City of Albuquerque Stormwater Construction Site Inspection Report

ESC File No.	K09E048D	Project Name:	Caliber Collision
NPDES Id. No.	NMR100607 & O8	Location:	250 98th St NW
10/21/2024	Owner	Contractor	
Operator	Goodwill Industries of New Mexico	Architectural Contractors Inc	
Contact name & title	Shauna Kastle CEO	Scooter Haynes	
e-mail	skastle@goodwillnm.org	Scooter@scmpartners.com	
Contact Phone #	505-881-6401 ext 9	898-6622	
COA Inspector	James Hughes	Time	9AM
Construction Phase:	Plumbing & footers		
Type of Inspection:	Regular	Storm Event	Post Storm Event >0.25"
		311/Complaint	Follow Up
Weather at time of inspection?		Temperature: ~	50
Estimated date of last storm 0.25" or greater		10/19/2029

| Sheet No.: C-6.0            |                 |

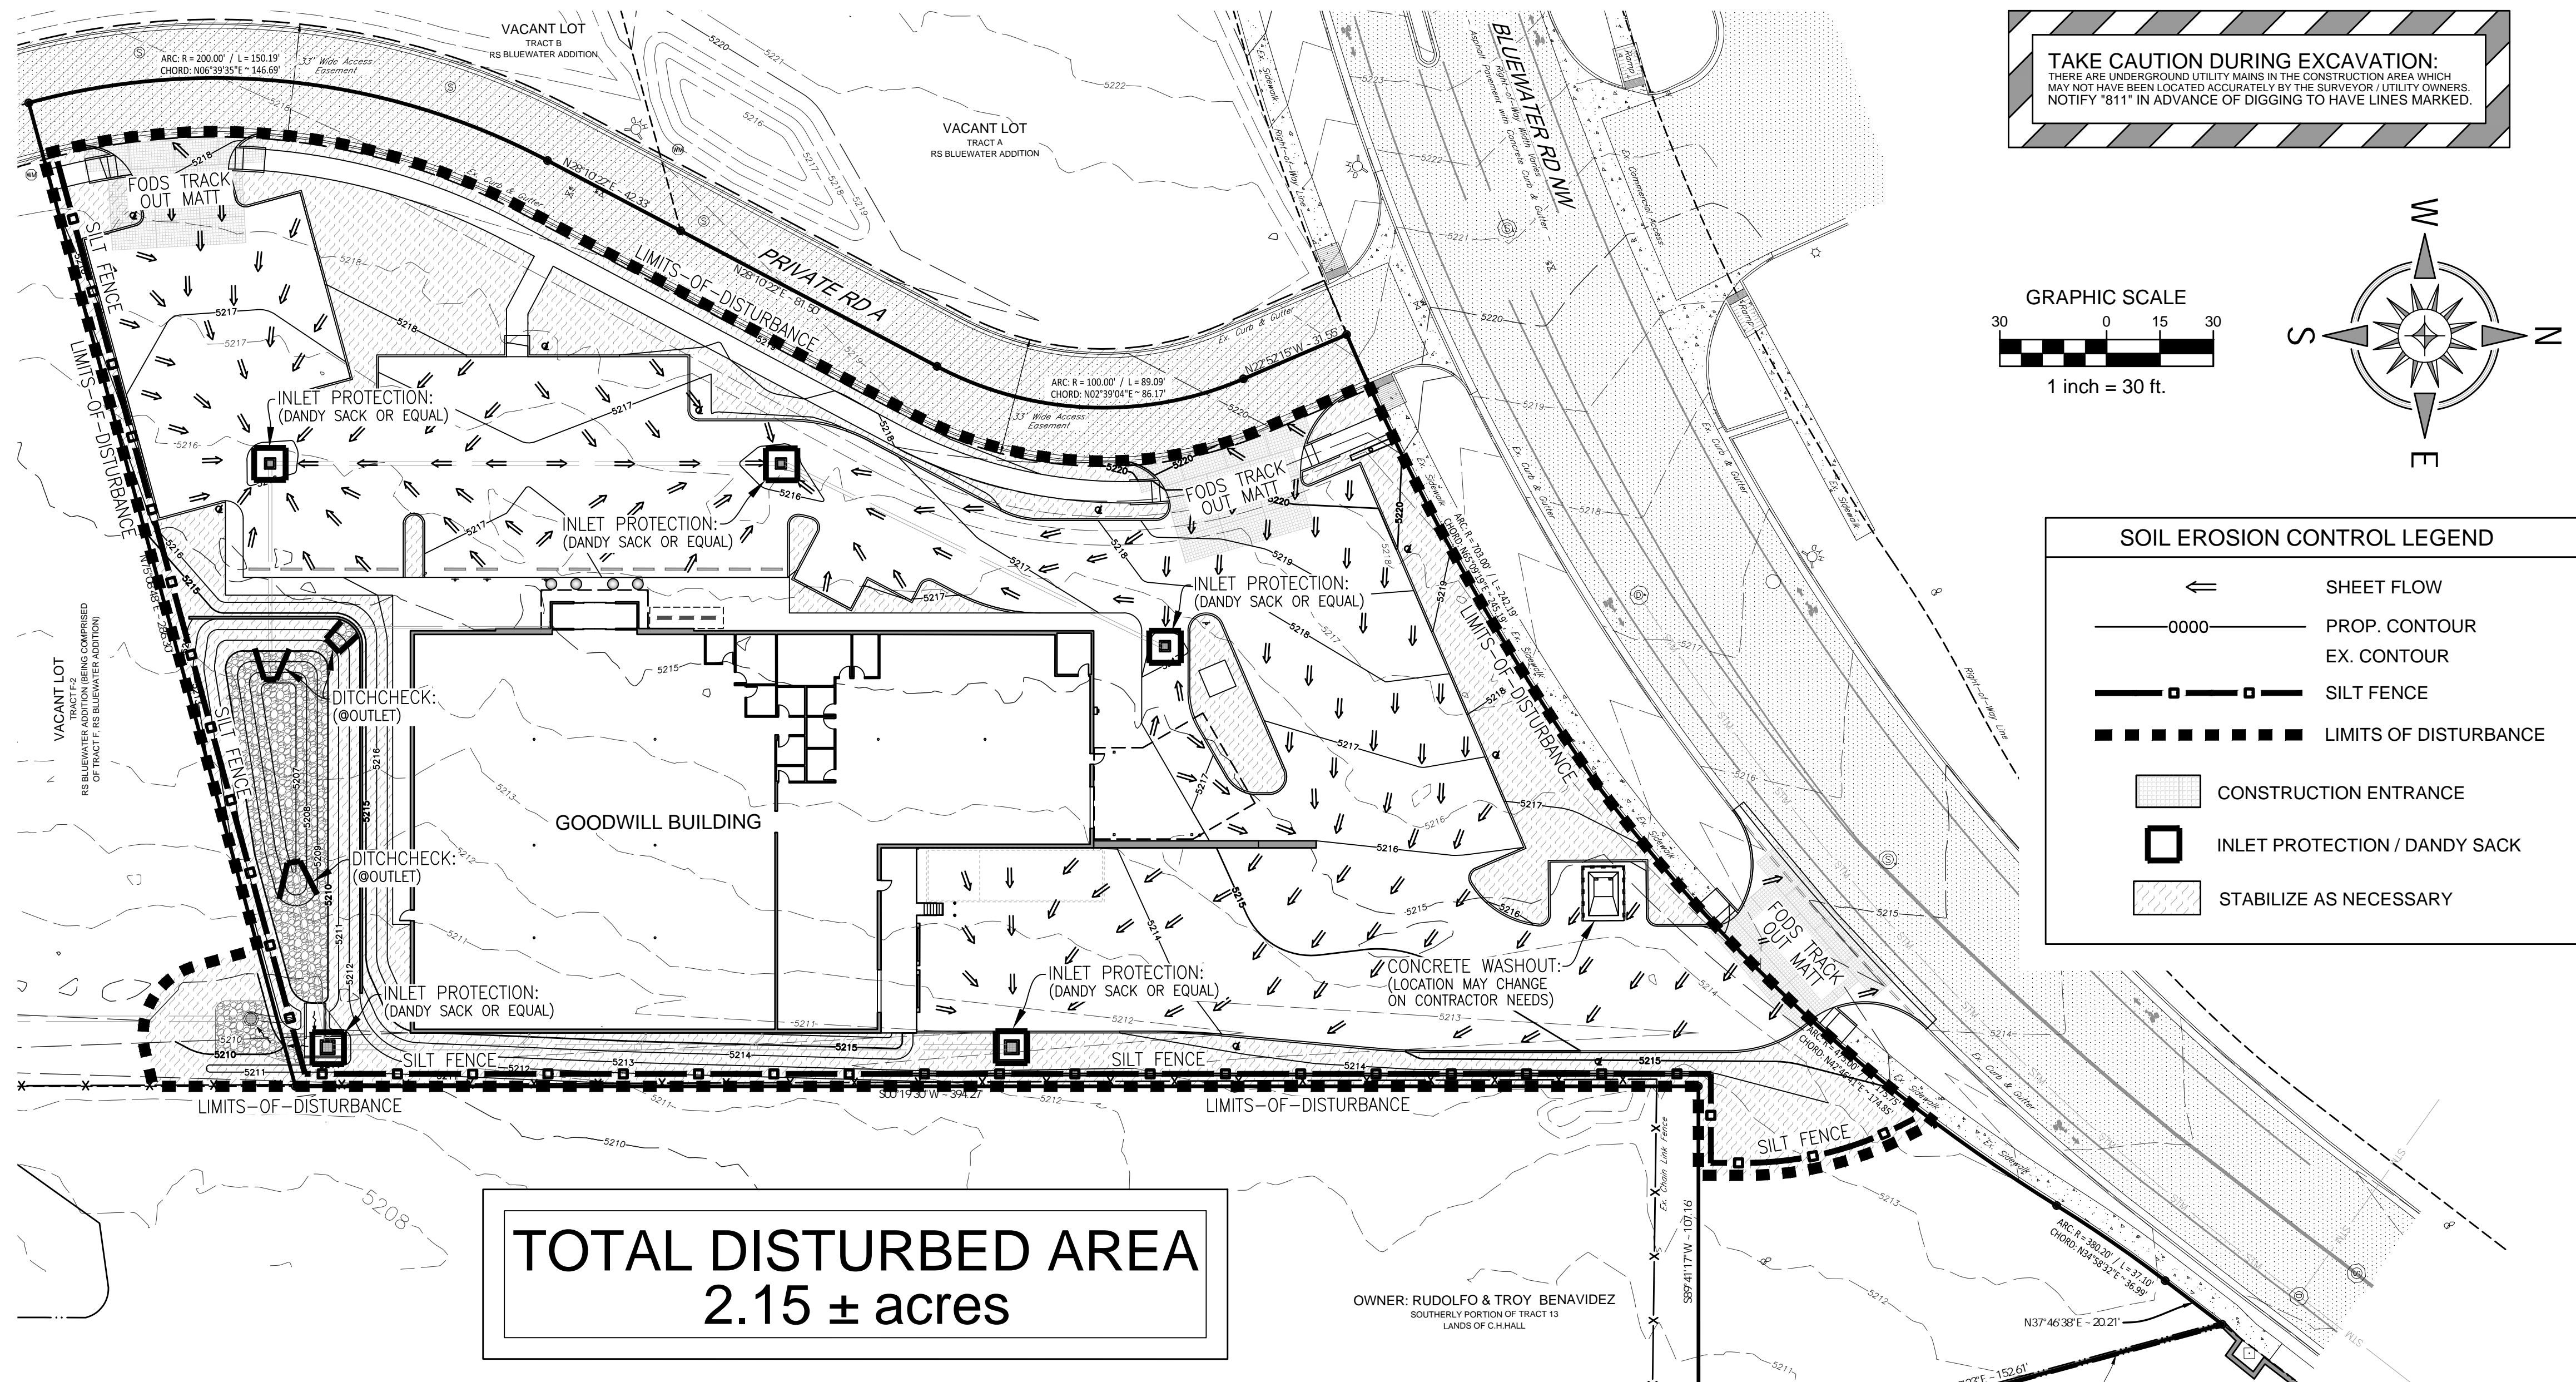
3	<b>BMPs</b> - Perimeter Silt Fence (SF) was in place, but the Construction Exit (CE) was missing. The site drains to the Southeast Corner, where concentrated flow exits the site. The SF in the SE Corner is inadequate for concentrated flow. Additional stormwater controls are not designed in violation of CGP 2.1.4, which requires the Operator to "Design and install all stormwater controls in accordance with good engineering practices, including applicable design specifications." The installation of the stormwater controls wasn't complete before the beginning of Construction Activities in Violation of CGP 2.1.3. <b>Required mitigation:</b> Additional stormwater controls, ponds, berm, and CE must be designed and installed in accordance with CGP 2.1.4 no later than seven (7) calendar days from the time of discovery per CGP 5.2.1.		
4	<b>Stabilization</b> —About half of the perennial vegetation was removed from this site in a 35' wide strip around the edges plus about 0.25-acre pad site in the south 80 of the site as part of the subdivision development that started in late 2022, and this site was still under permit coverage when Goodwill purchased it on 12/29/2023. The edges were Hydromulched in mid-2023 but didn't grow significant perennial vegetation, and the mulch had large bare spots before the end of 2023. The pad had thin spotty gravel cover in Aug 2024. At the time of the inspection on 10/21/24, the previously disturbed area had been scraped, moving vegetation and trash into piles, but the area of native vegetation remained undisturbed in the center third of the lot. <b>Required Mitigation:</b> Stabilize the disturbed areas that remain inactive for 14 days or more per CGP 2.2.14.c.i. Measures must be initiated within 14 days and completed no later than 14 days per CGP 2.2.14.
